April 24, 2020  
Merrick Project No. 65120399

**Re: Mountain View Academy - Site Development Plan;  
Grading and Erosion Control Plan (PPR-20-008)**

Merrick & Company has reviewed the comments dated March 17, 2020 regarding the Mountain View Academy Site Development Plan and Grading and Erosion Control Plan. The following summarizes Merrick's responses to the comments provided by the El Paso County.

JOB NUMBER	65120399
DATE	02/07/2020
SHEET	<b>C3.4</b>
13	of 20

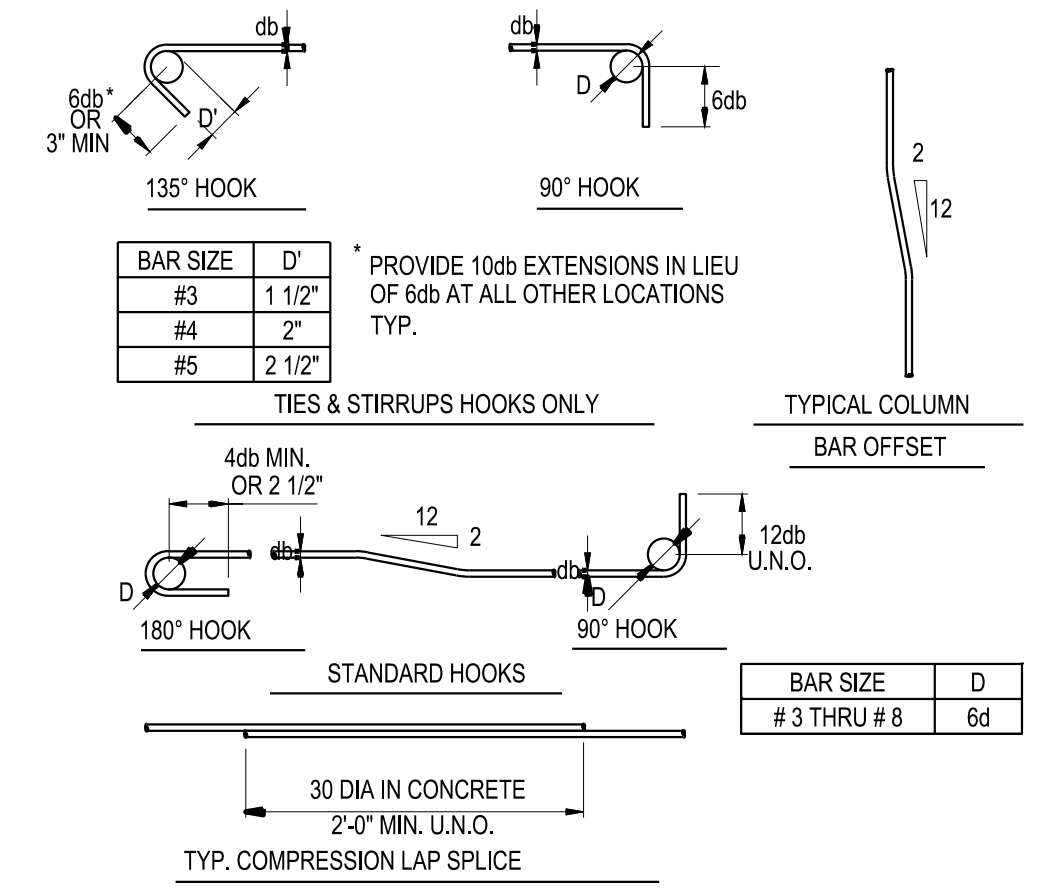
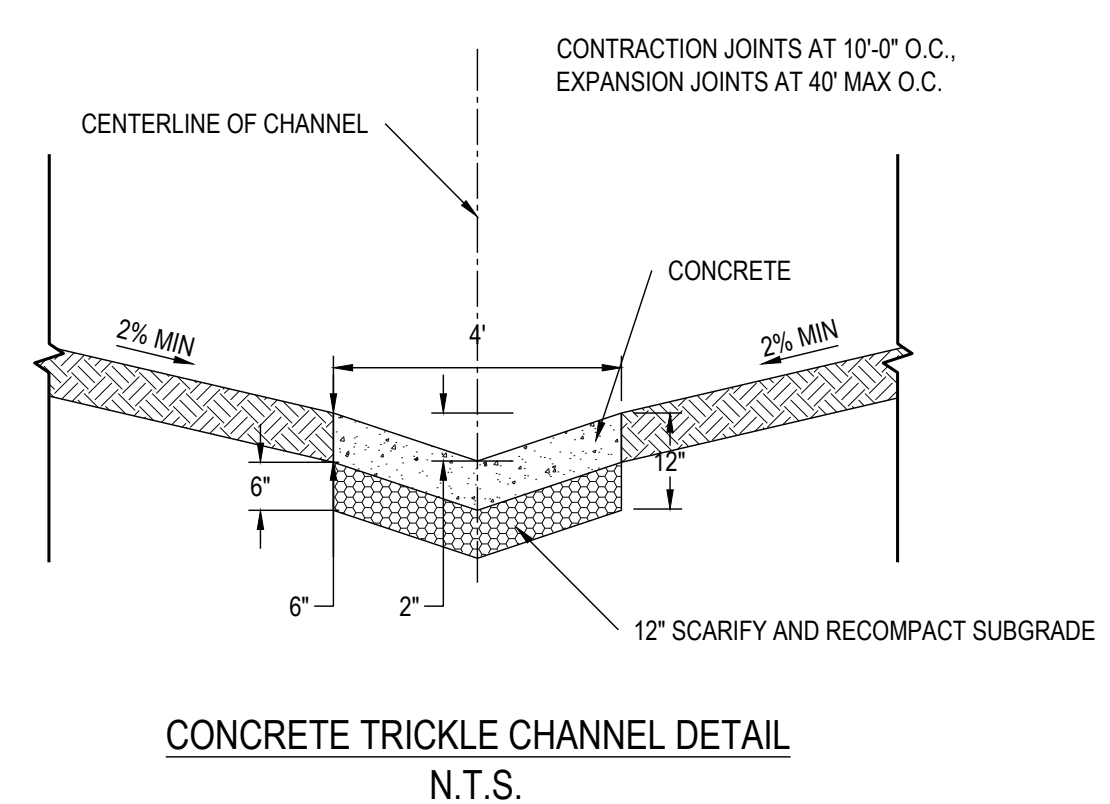
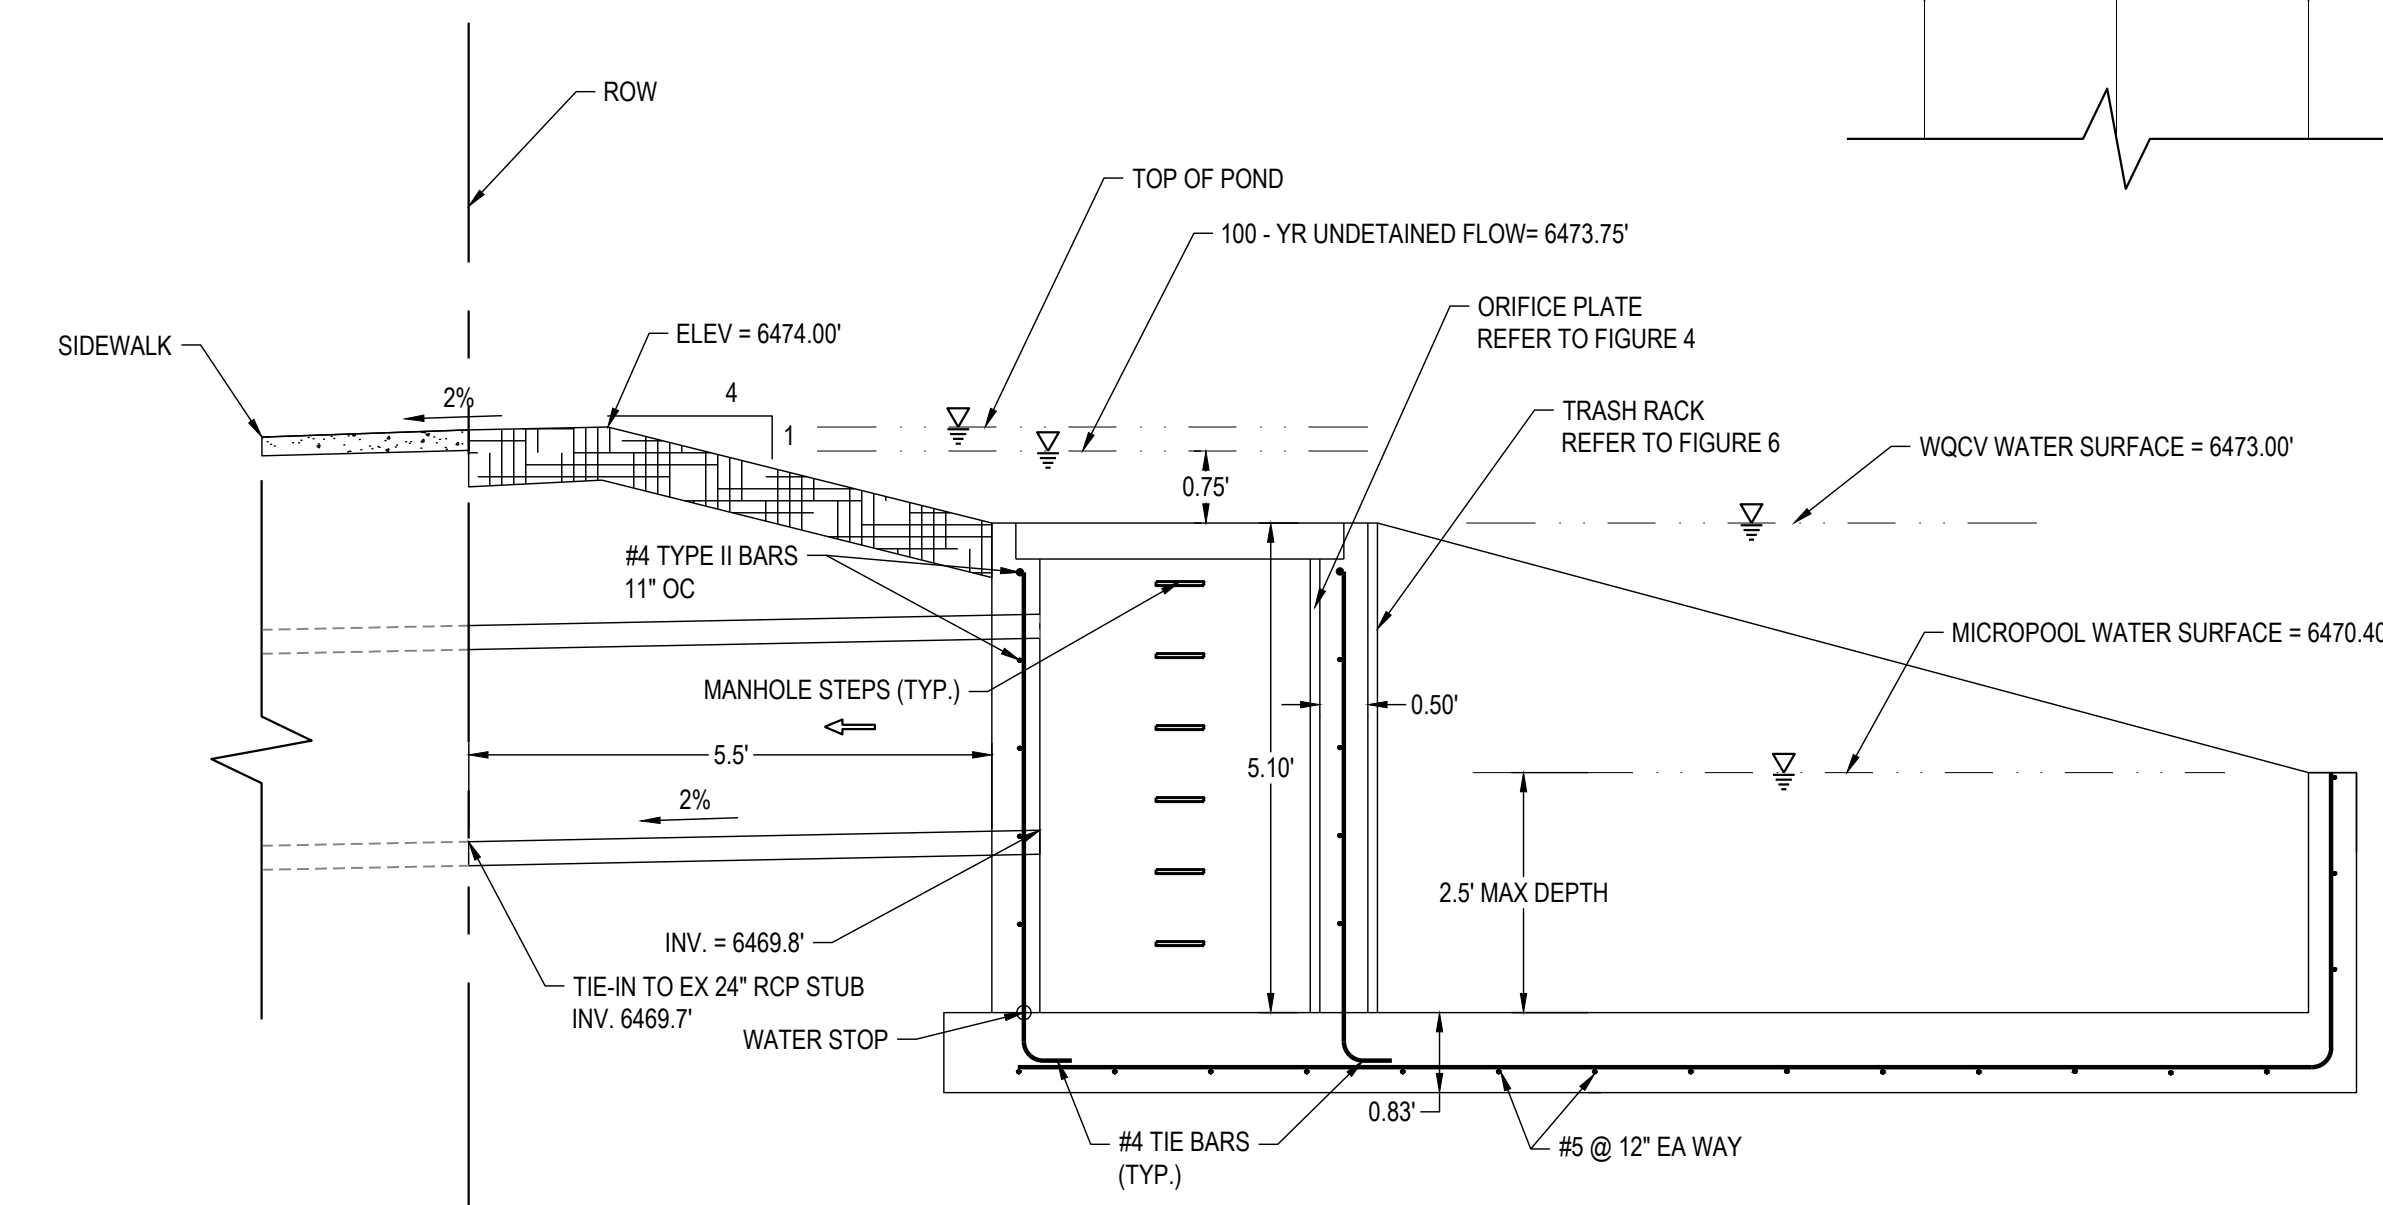
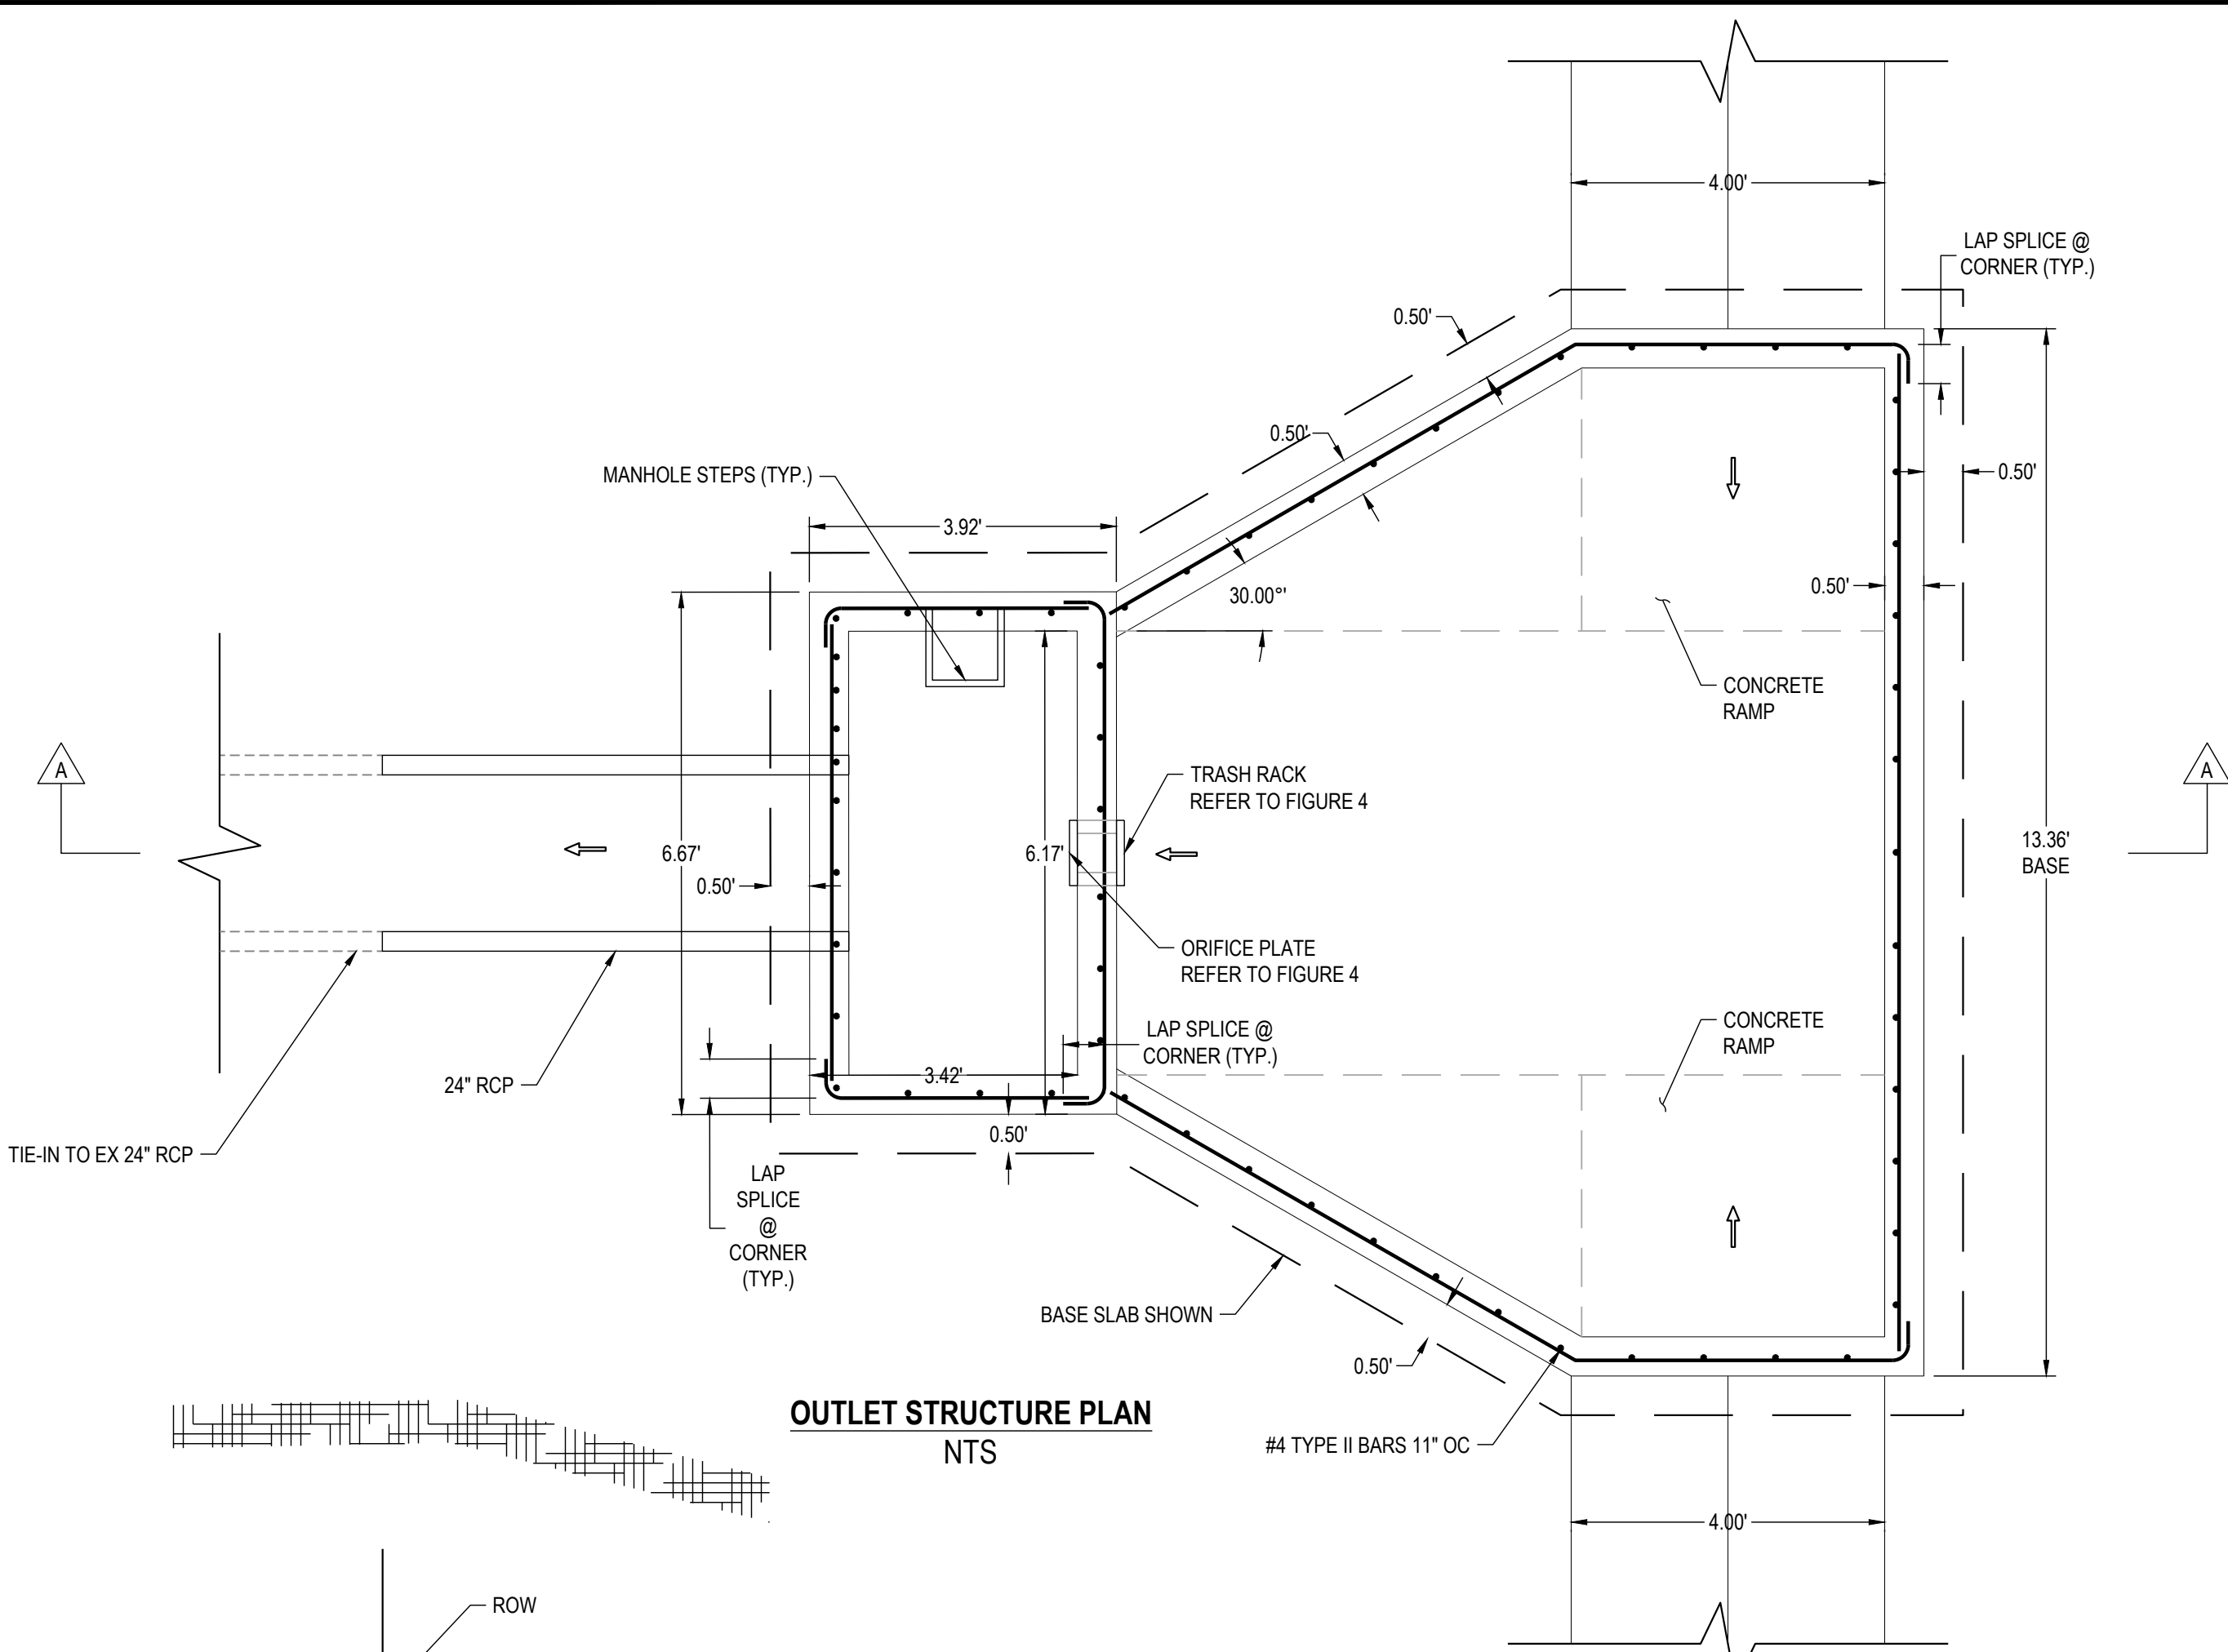
- Add slope tag. Slope be 2% or less along the pedestrian access route.  
[Response: Added](#)

DATE: 02/07/2020  
SHEET: C3.6  
15 of 20

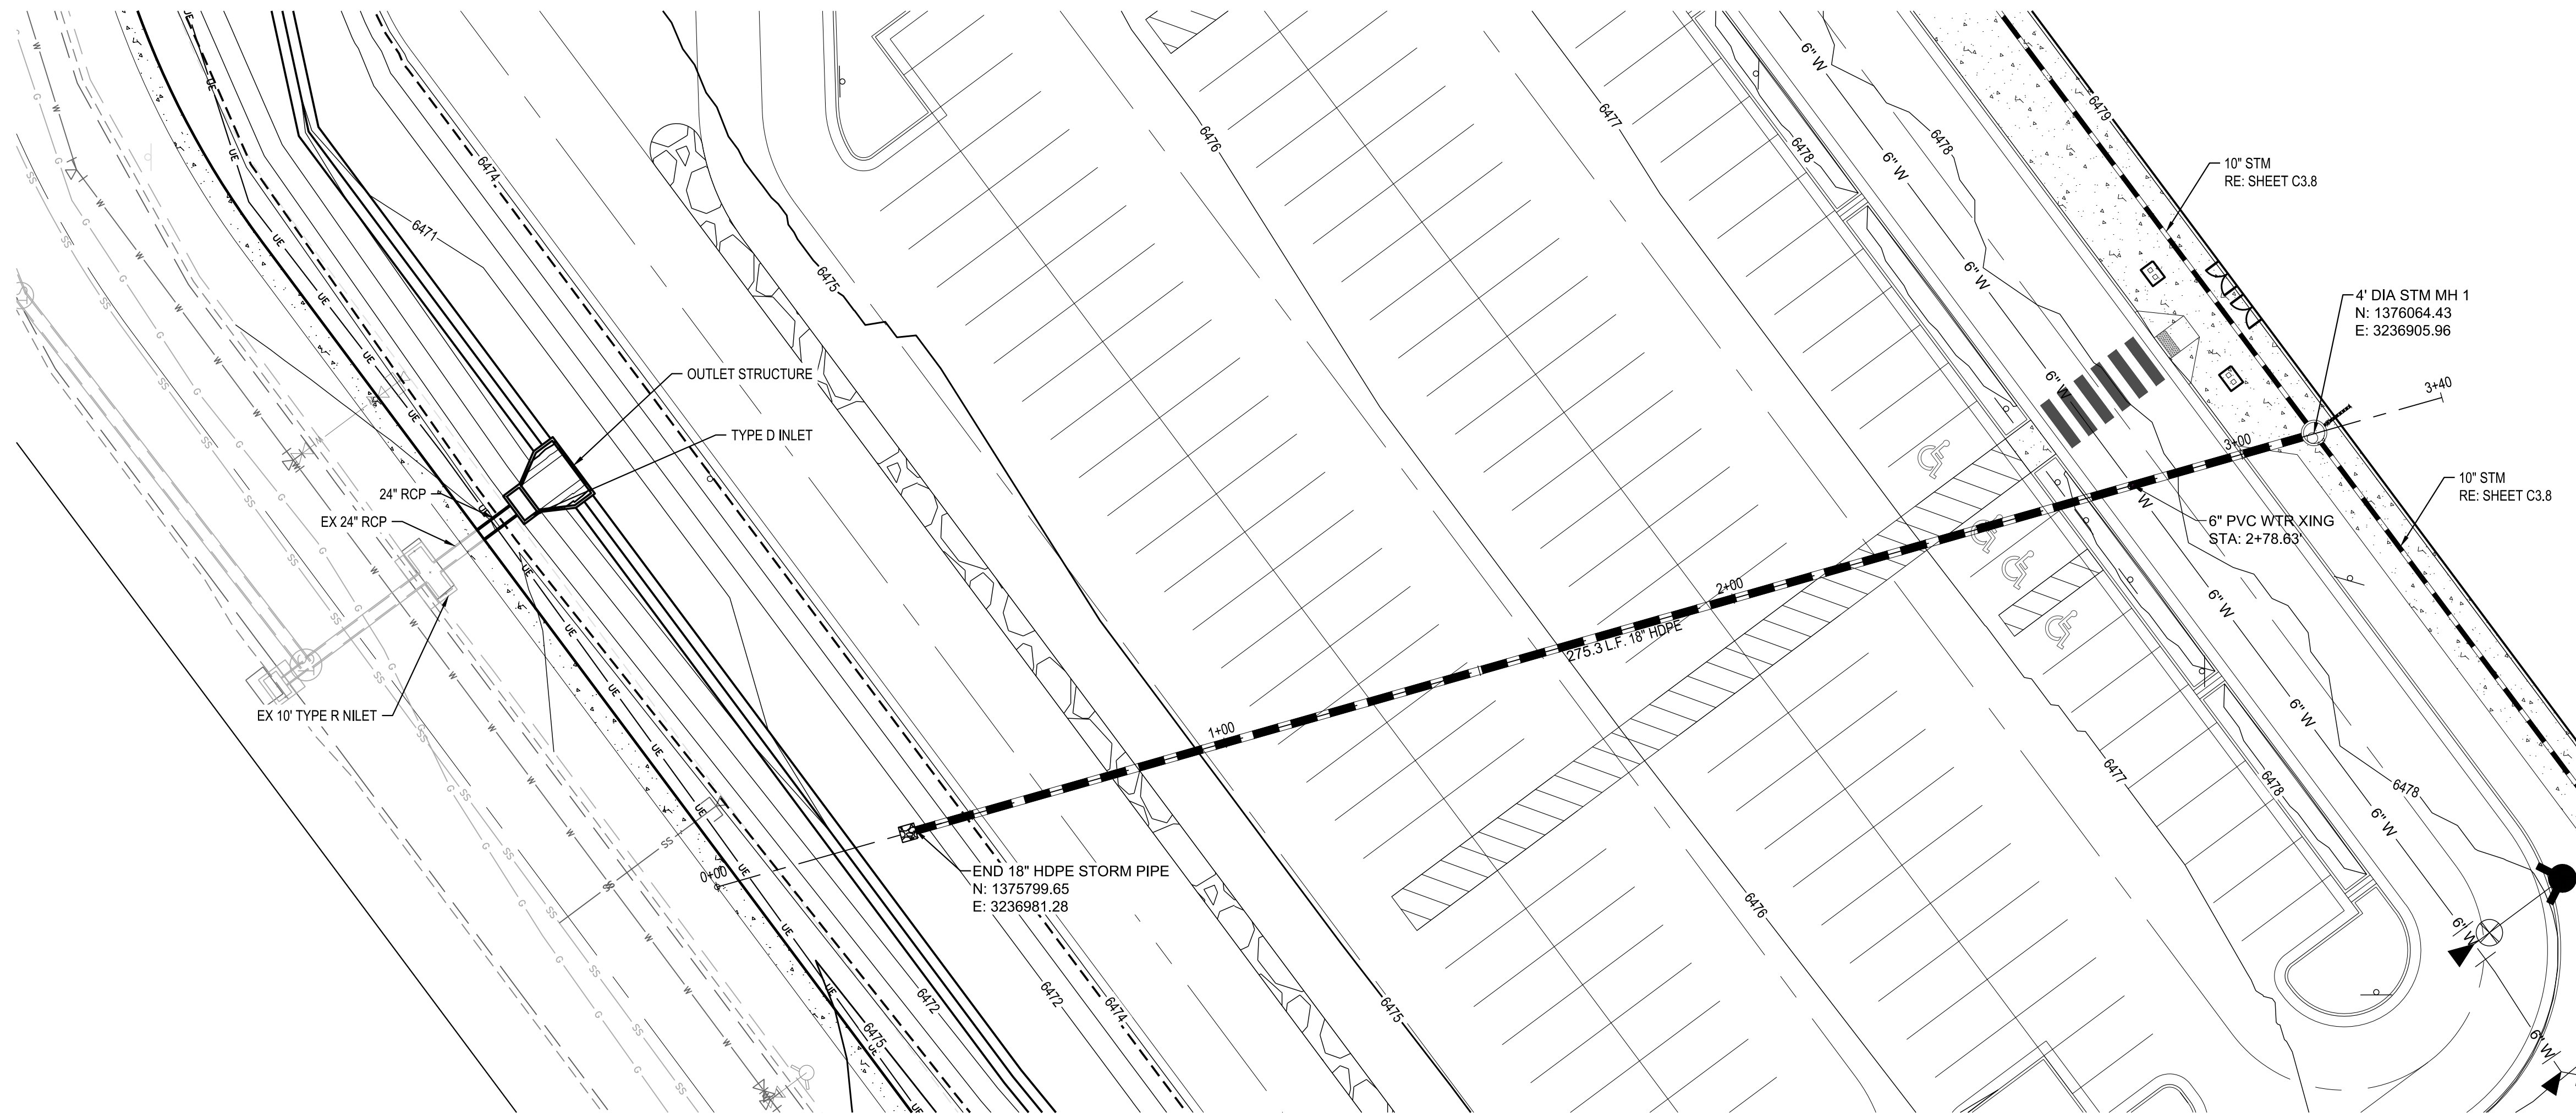
- Pond design will be reviewed on the resubmittal. Pond design may be altered significantly based on comments in the drainage report.  
[Response: Understood](#)
- Gasket required between concrete and Orifice Plate  
[Response: Understood](#)
